DELEGATED DECISION TO DETERMINE PLANNING APPLICATIONS

Reference No:	2026/62/92216/W
Site Address:	Stalley Royd Farm, Stalley Royd Lane, Jackson Bridge, Holmfirth, HD9 7HX
Description:	Alterations to convert one dwelling to two dwellings (Listed Building)
Recommending Officer:	Joanna Rednall

DECISION – Conditional Full Permission

Elevations as Proposed

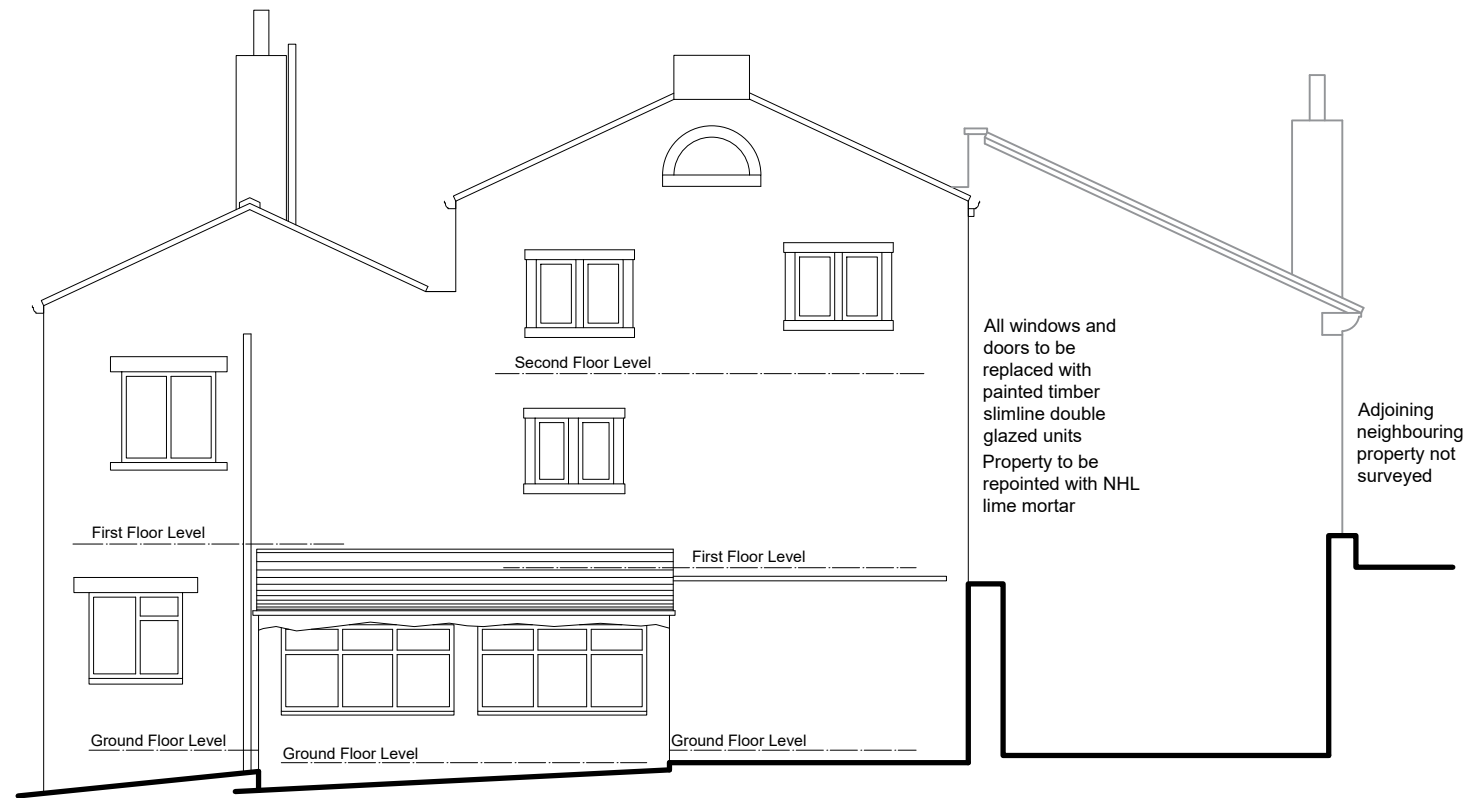
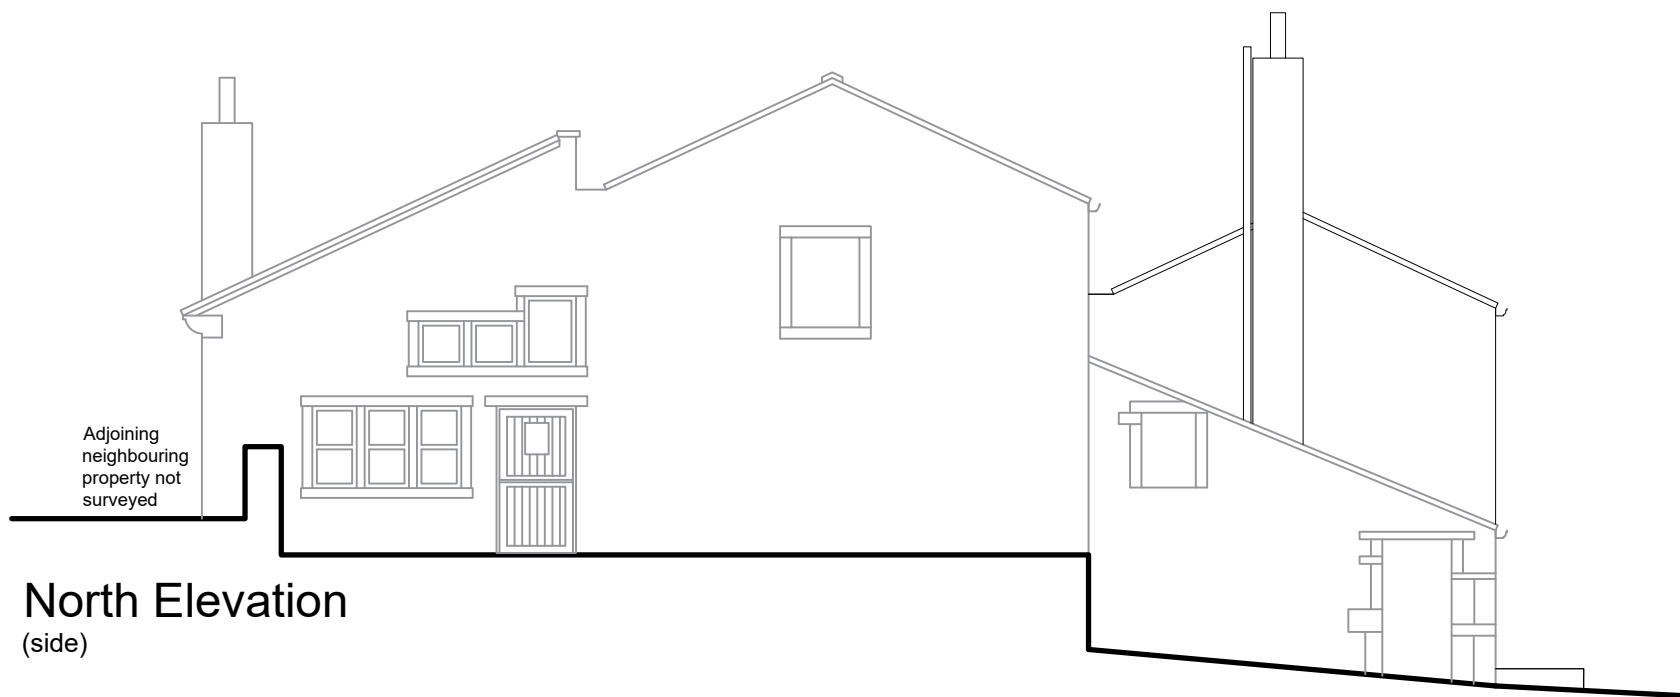
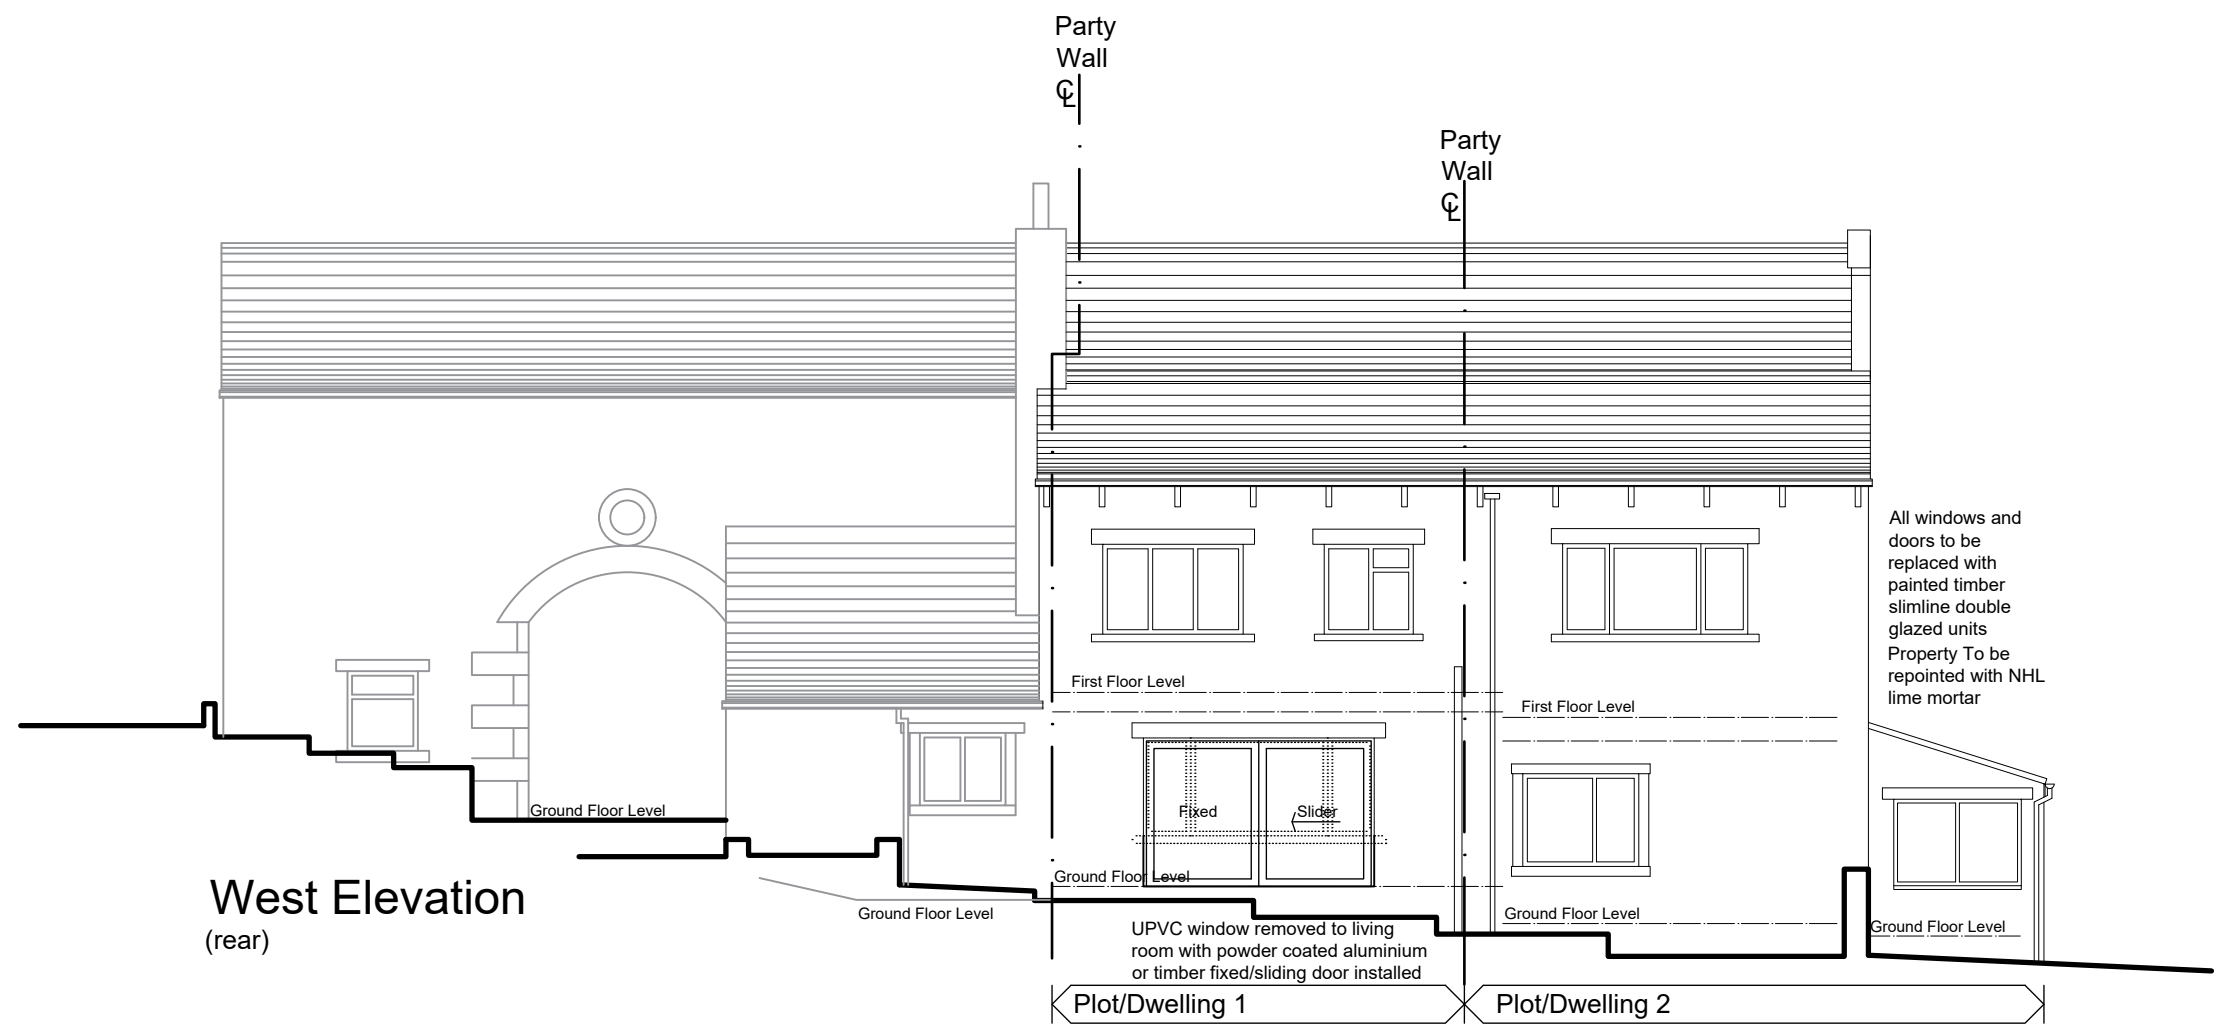
KC Conservation and Design: no objection, however recommend for the French doors to the rear / west facing elevation to be constructed from timber.

The Council's Conservation and Design Officer has been verbally consulted during the course of this application and has raised no objection in principle to the proposal. However, the Officer has recommended that the proposed French doors on the rear (west-facing) elevation should be constructed in timber.

The submitted plans identify powder-coated aluminium or timber as options for the proposed sliding doors, which would be sized to correspond with the existing window opening. The applicant's agent has advised that the west-facing elevation is exposed to prevailing weather conditions and that powder-coated aluminium is preferred on grounds of durability and performance. The agent has also noted that the doors would replace an existing modern uPVC window.

In considering the proposed material, consideration has been had to the location of the opening, the character of the elevation and the existing window to be replaced. The west-facing elevation is less prominent than the principal elevations, and the existing uPVC window is not identified as a historic feature. The proposed doors would be installed within the existing opening, with no change to the building's external envelope.

On this basis, officers consider that the use of powder-coated aluminium at this location would result in a limited degree of harm to the special architectural and historic interest of the listed building. The proposal would therefore need to be assessed against the public benefits arising from the works, including the reinstatement of the building's historic dual-occupancy arrangement and its continued residential use.

3. The fixed/sliding door to the west / rear elevation hereby approved shall be either timber or powder coated aluminium framed and set back in the reveal by 100-125mm and not fitted flush with the external wall.

Proposed Block Plan

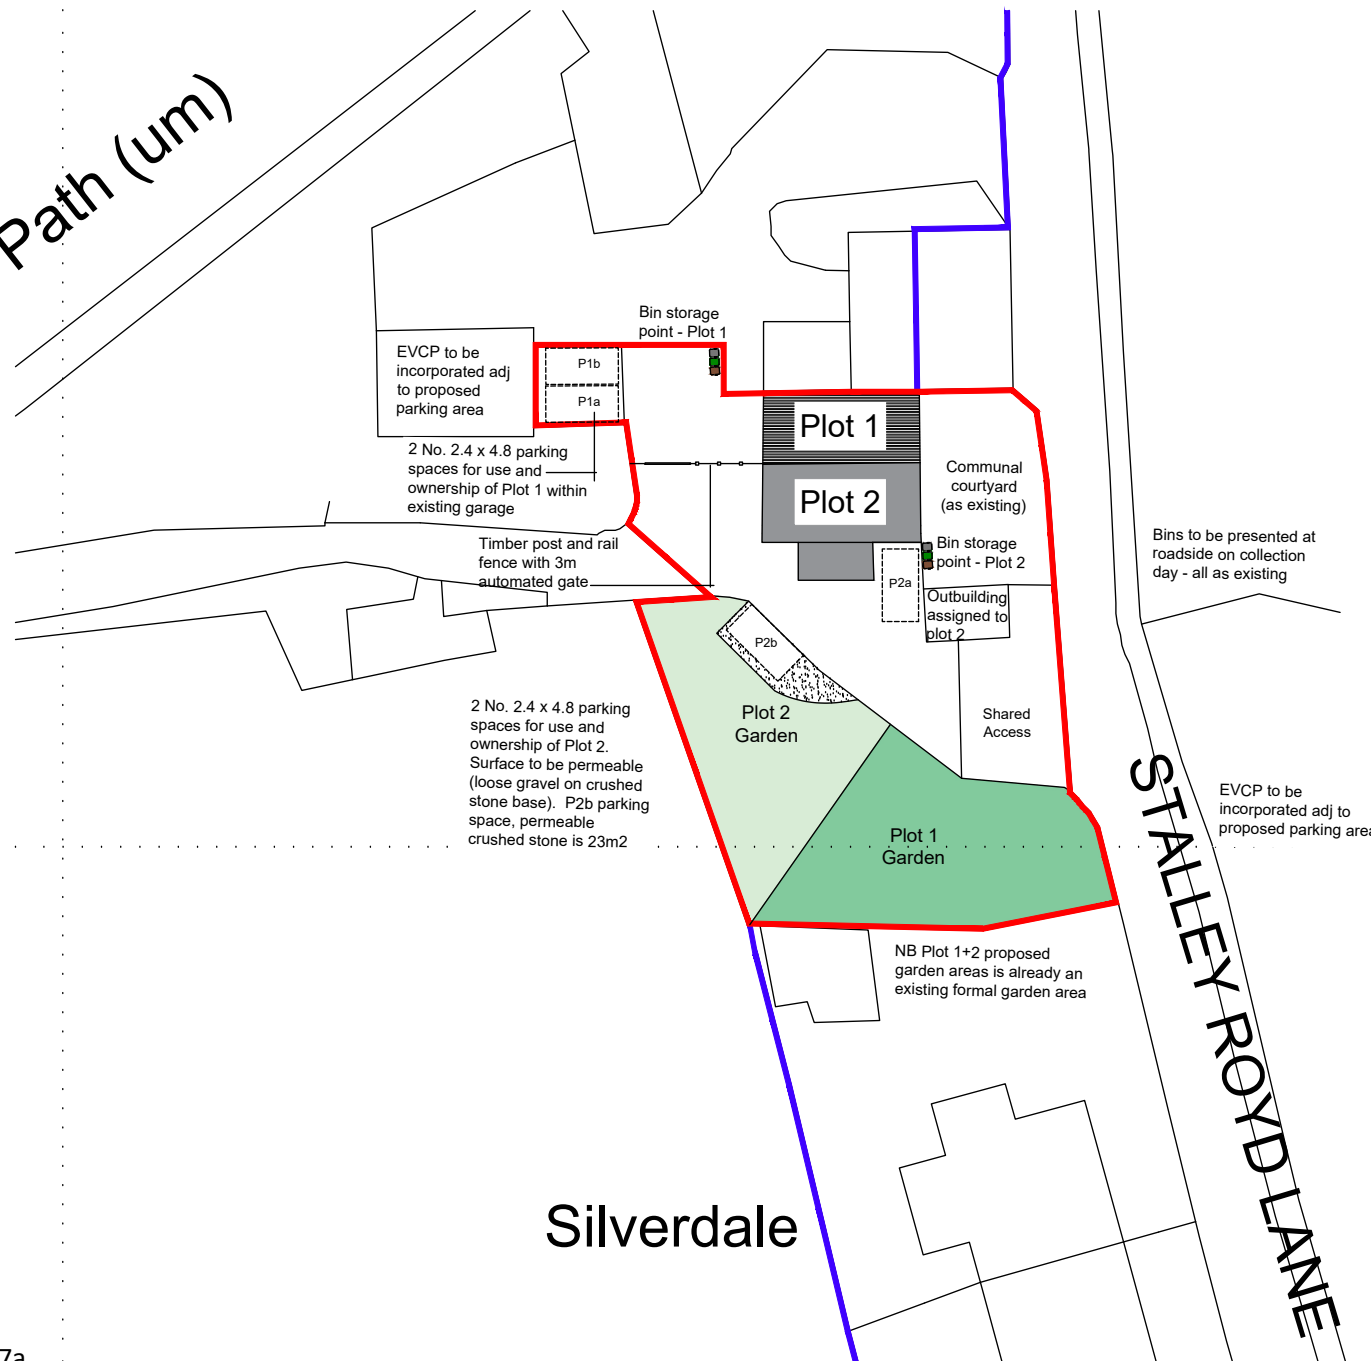
Officers note that an area of hardstanding is proposed within the garden of Plot 2 to provide a parking space. Highways officers have requested a condition requiring the use of permeable surfacing for parking areas, which would be imposed should permission be granted.

4. Prior to the development being brought into use, the approved vehicle parking areas shall be surfaced and drained in accordance with the Communities and Local Government; and Environment Agency's 'Guidance on the permeable surfacing of front gardens (parking areas)' published 13th May 2009 (ISBN 9781409804864) as amended or superseded; and thereafter retained throughout the lifetime of the development.
